Development Review Board Comments

Project Number: 1002540
Application Number: 03DRB-00423

Tract 2-B-2 & 74-B MRGCD Map #35

DEVELOPMENT REVIEW BOARD TRANSPORTATION DEVELOPMENT Standard Comment Sheet

**SKETCH PLAT OF  
 TRACTS A THRU. G  
 JONATHAN MEADOWS**

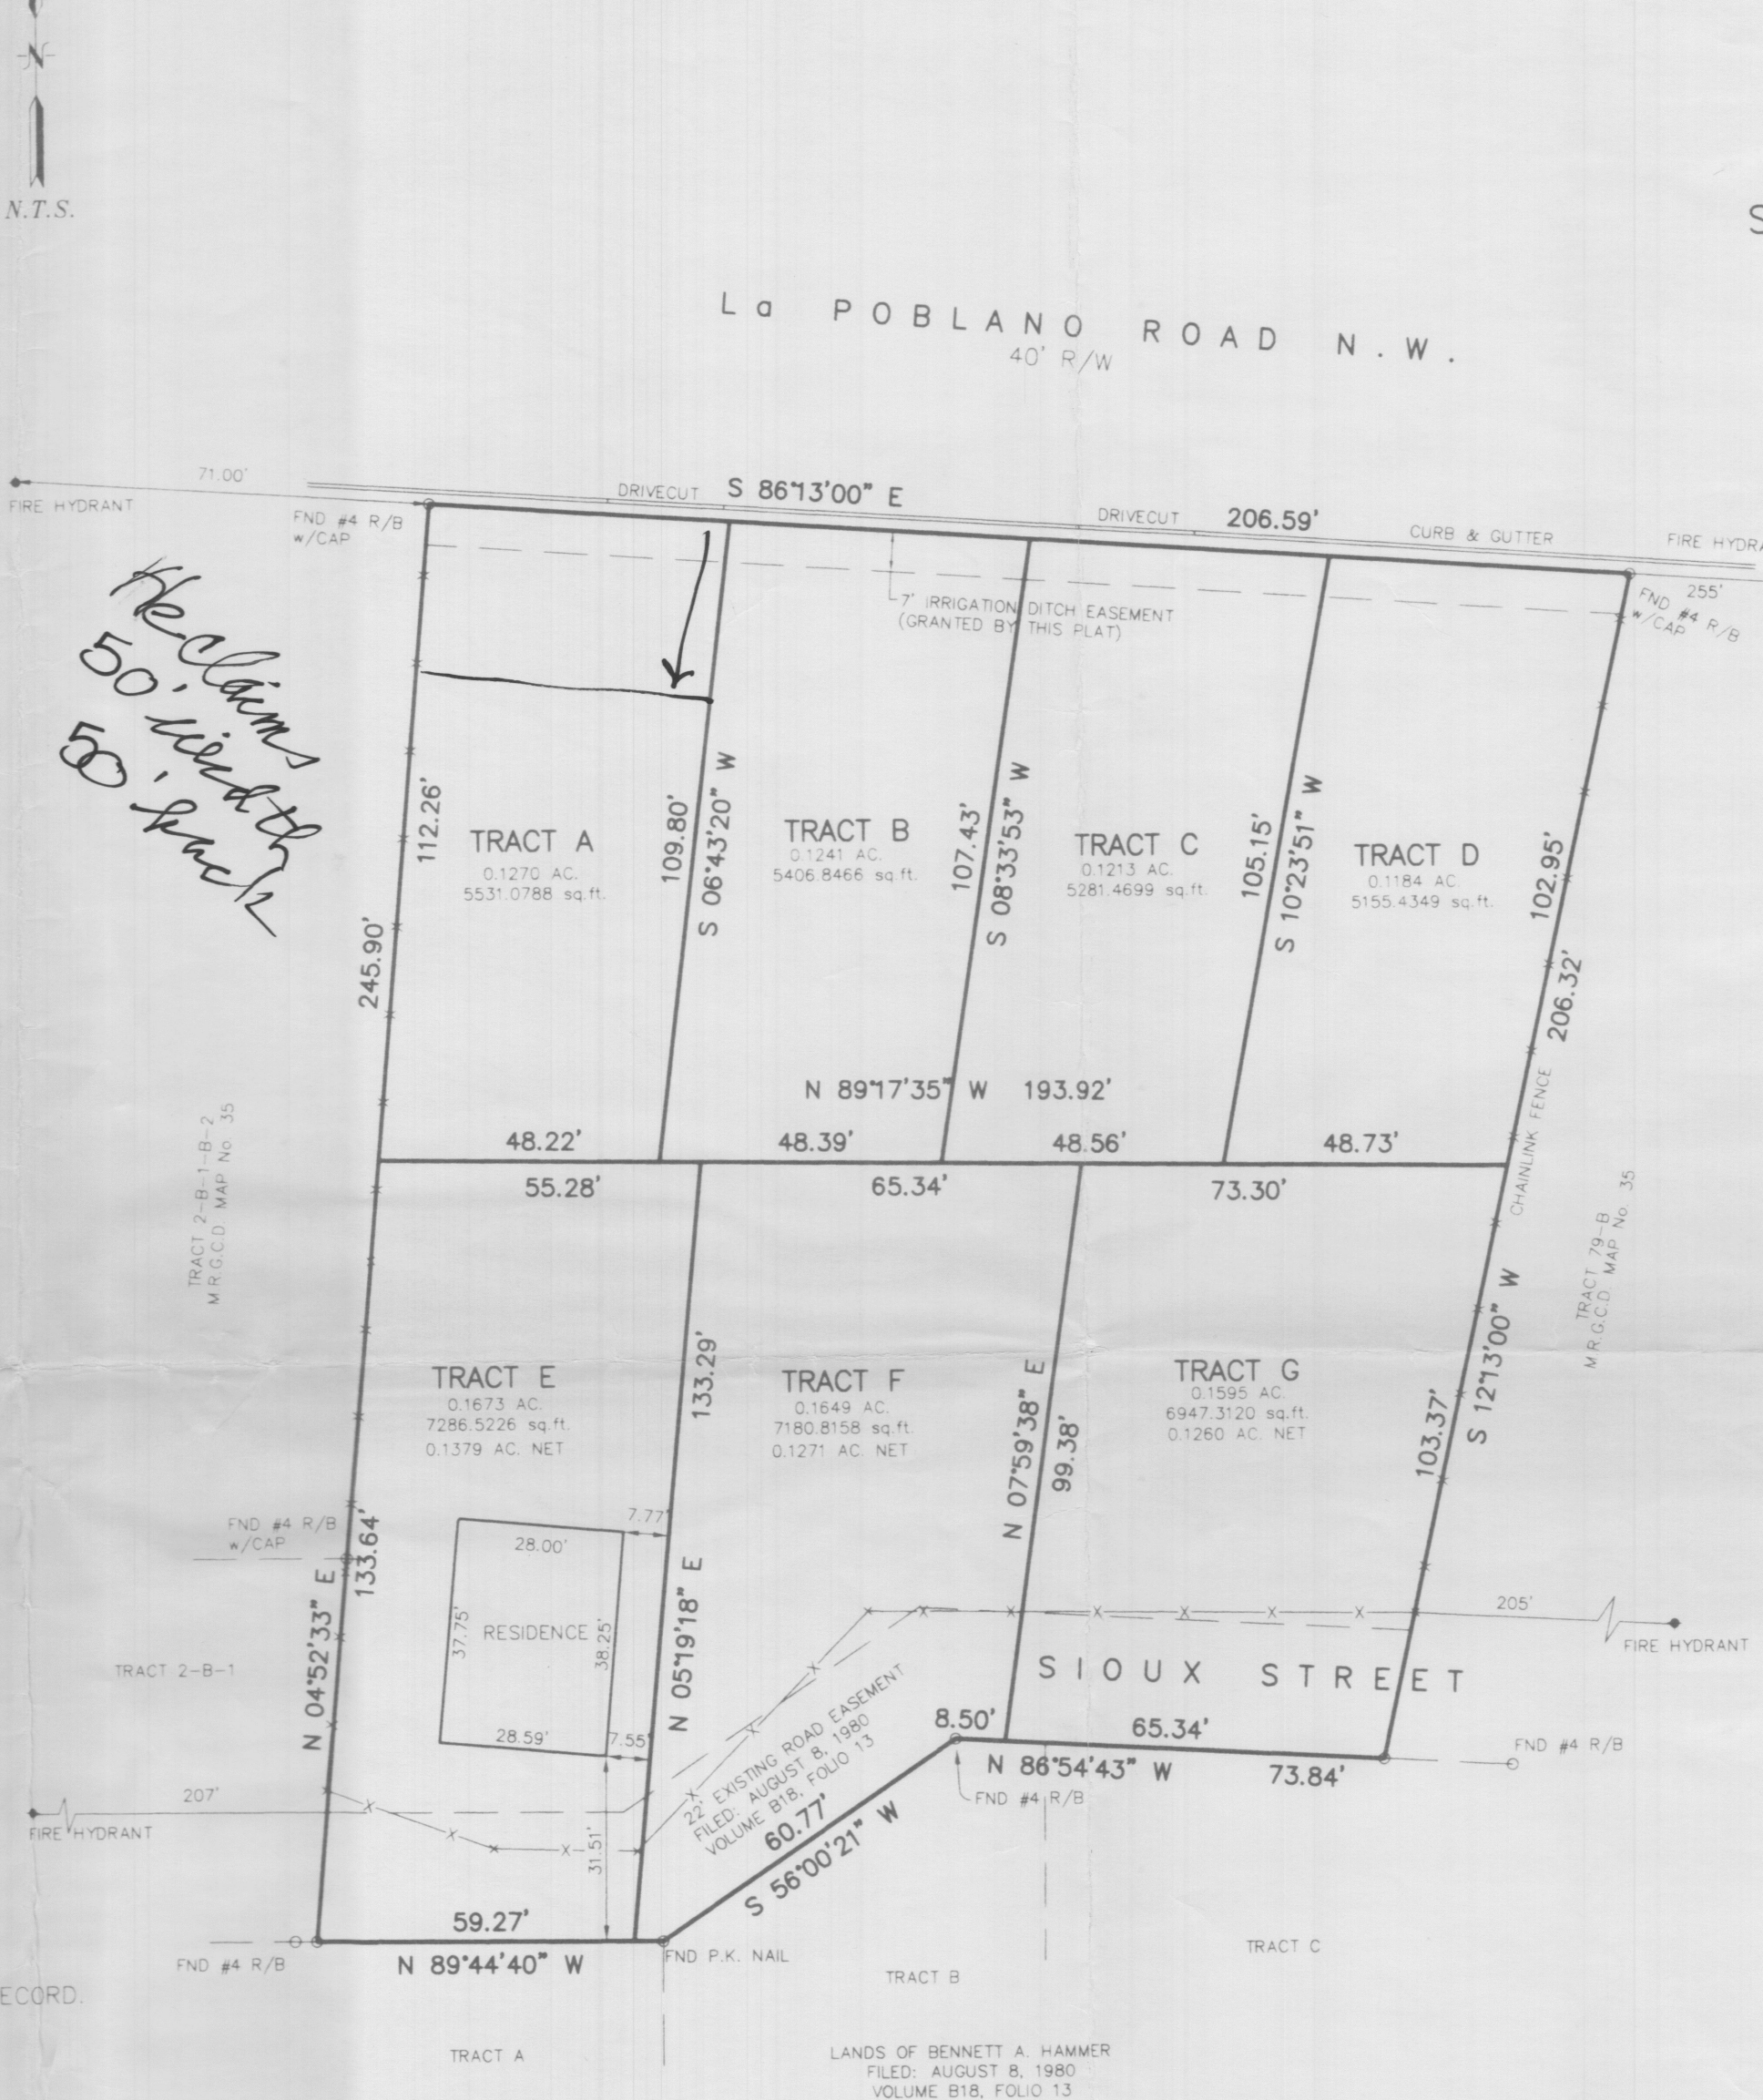
No.	Comment
<input type="checkbox"/>	A site sketch showing the street infrastructure is needed. Right-of-way dedication and street improvements may be required.
<input type="checkbox"/>	A cul-de-sac for Sioux street appears to be warranted.
<input type="checkbox"/>	Right-of-way dedication, 9ft from the face of curb on La Poblana is required, along with sidewalk.
